Application by Port of Tilbury London Limited for an Order Granting Development Consent for a Proposed Port Terminal at the Former Tilbury Power Station ('Tilbury2') Ref: TR030003

The Examining Authority's Agenda on the Applicant's draft development Consent Order (dDCO) 28th June 2018

Thurrock Council (TC) written response to agenda items

Deadline 5 – 6th July 2018

## TRAFFIC REGULATION MEASURES PLAN

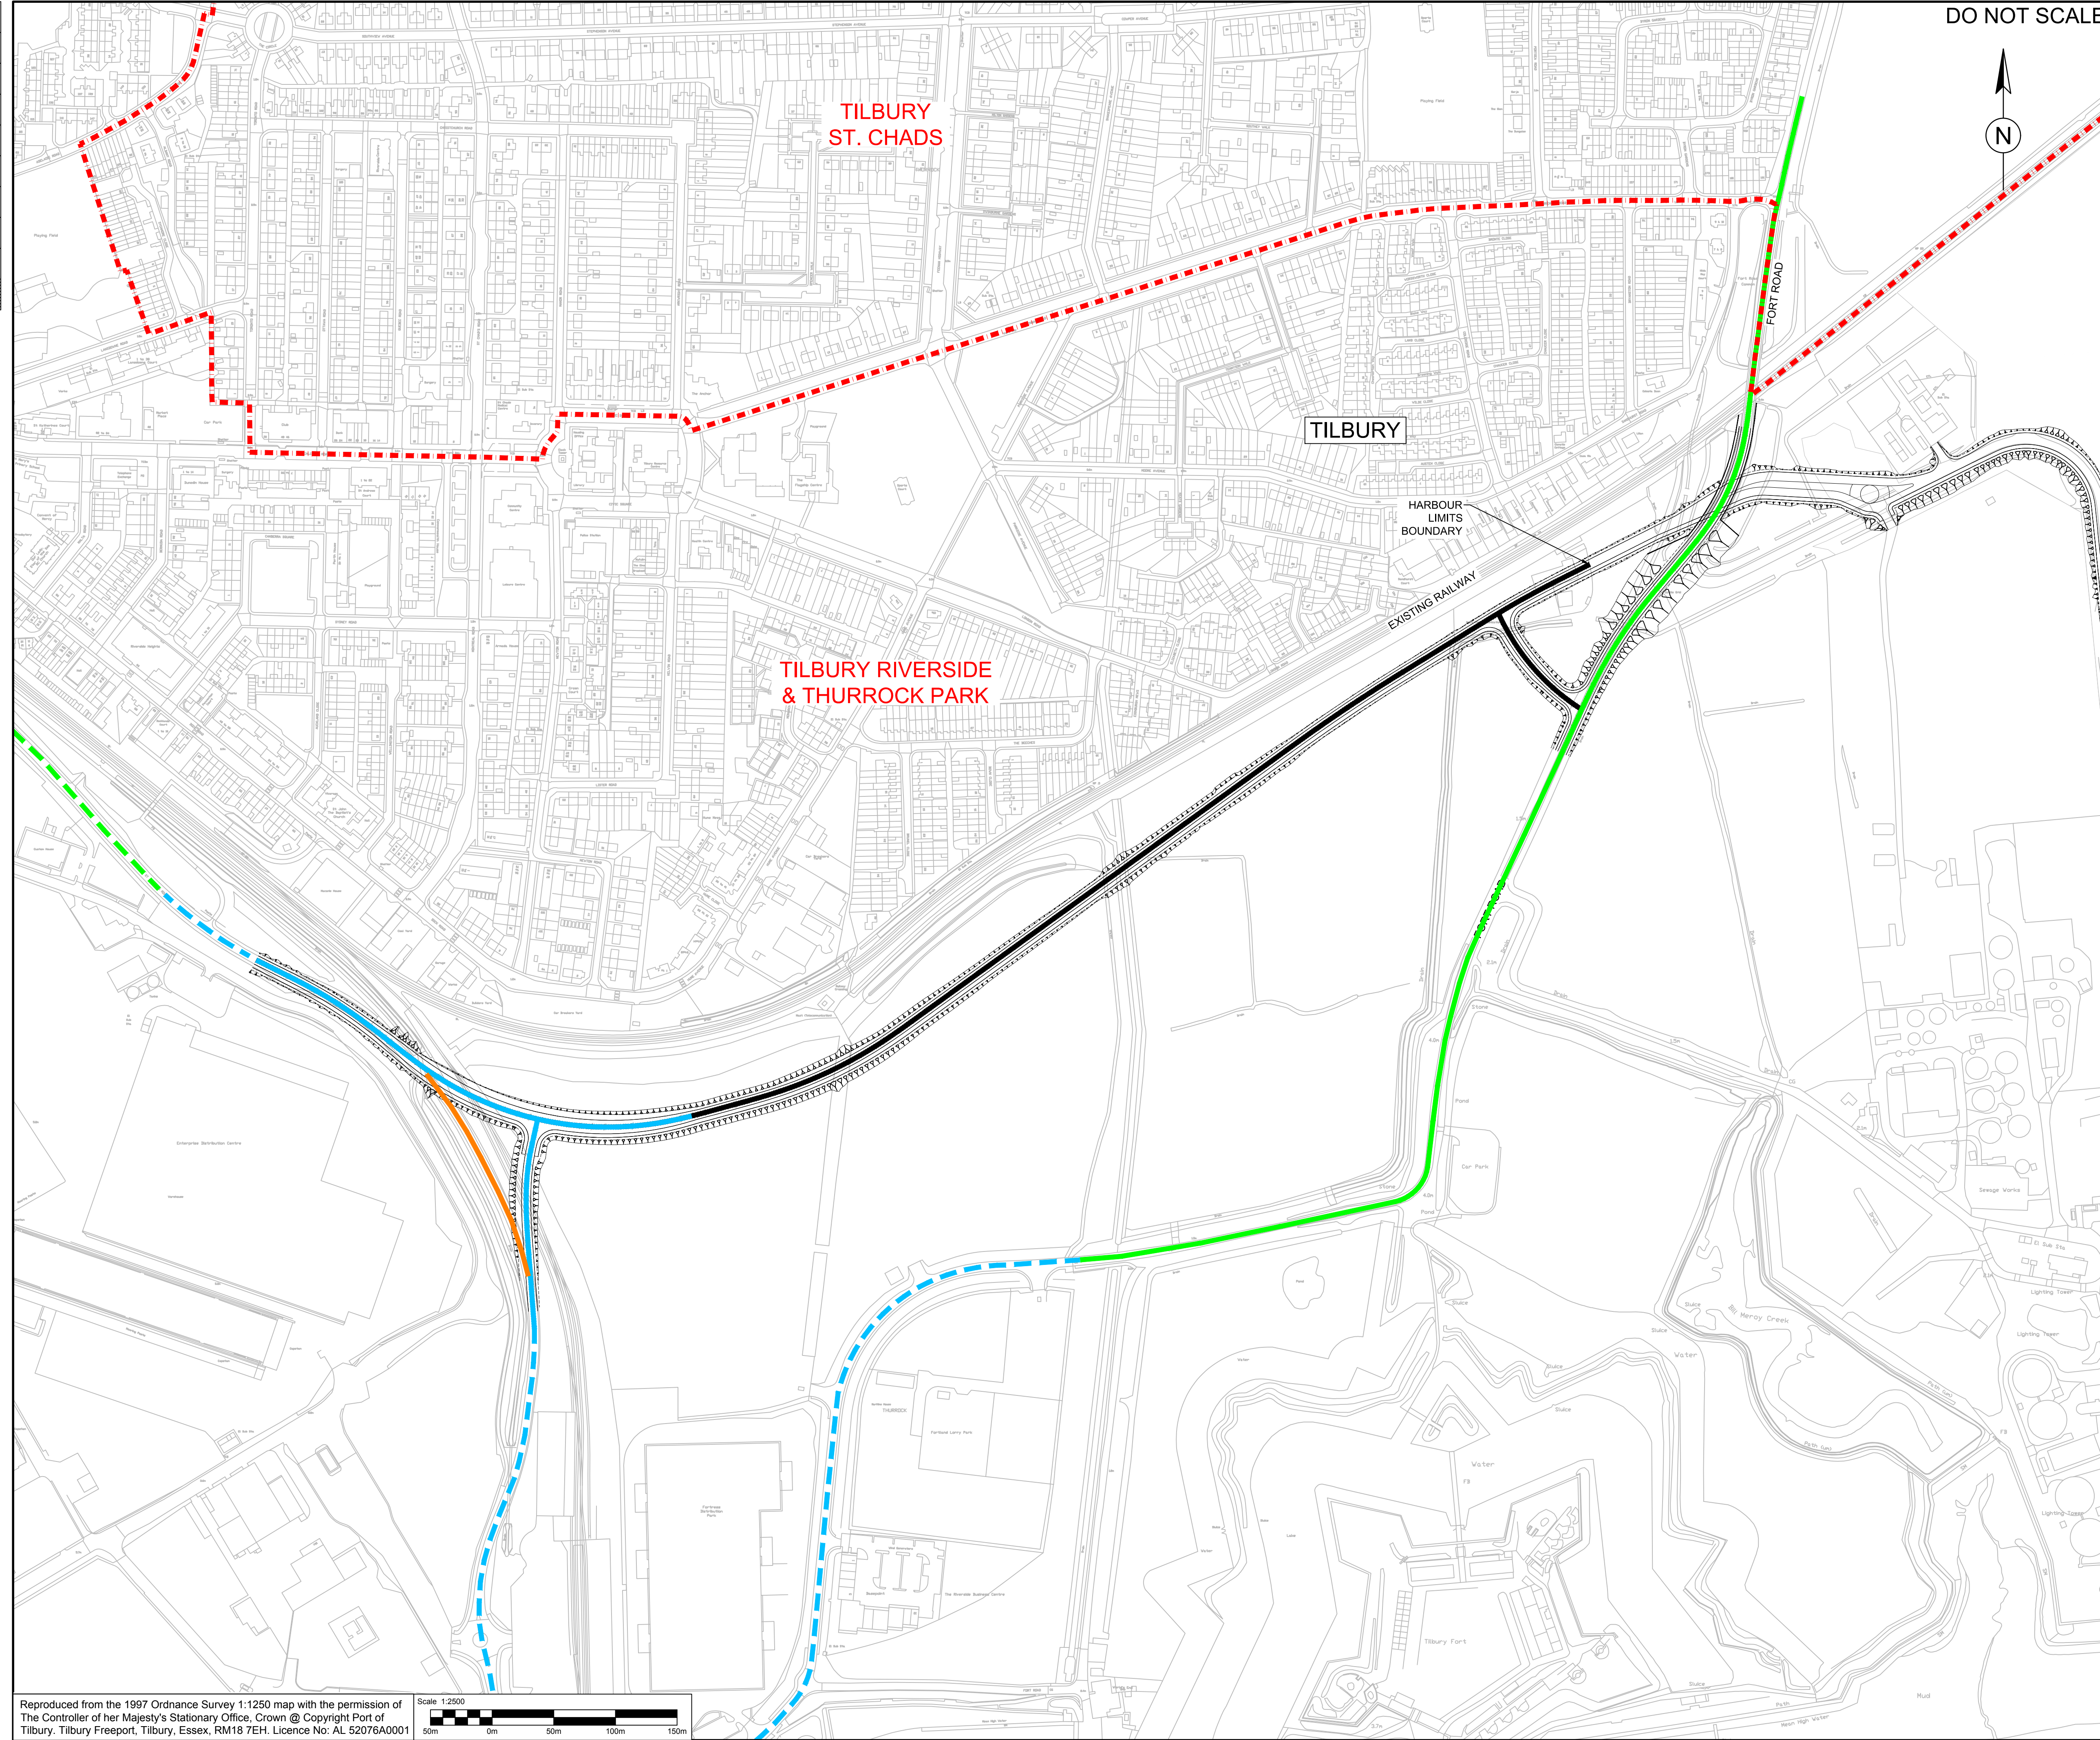
3.8.16.	Art 52: Traffic Regulation Measures	With reference to TC's and HE's responses at deadline 4 [REP4-005, REP4- 002] to ExA's SWQs [PD-010], Q2.8.33 ... i. Would the Applicant, TC and HE update the Examination on their positions re traffic regulation measures?	i. This matter is still under discussion. TC echoes the concerns made by HE at the Hearing.

3.8.26.	Schedule 8: Traffic Regulation Measures etc	<p>With reference to the Applicant's, TC's and HE's responses at deadline 4 [REP4-020, REP4-005, REP4-002] to ExA's SWQs [PD-010], Q2.8.46 ...</p> <p>i. Would the Applicant, TC and HE update the Examination on the status of Schedule 8, highlighting any areas still to be resolved?</p>	i. This matter is still under review in light of the updated information within the draft DCO (revision 3) which was uploaded to the National Infrastructure Planning web-site on 19th June 2018. TC notes that the proposed changes to the ASDA roundabout will need to be included in this Schedule
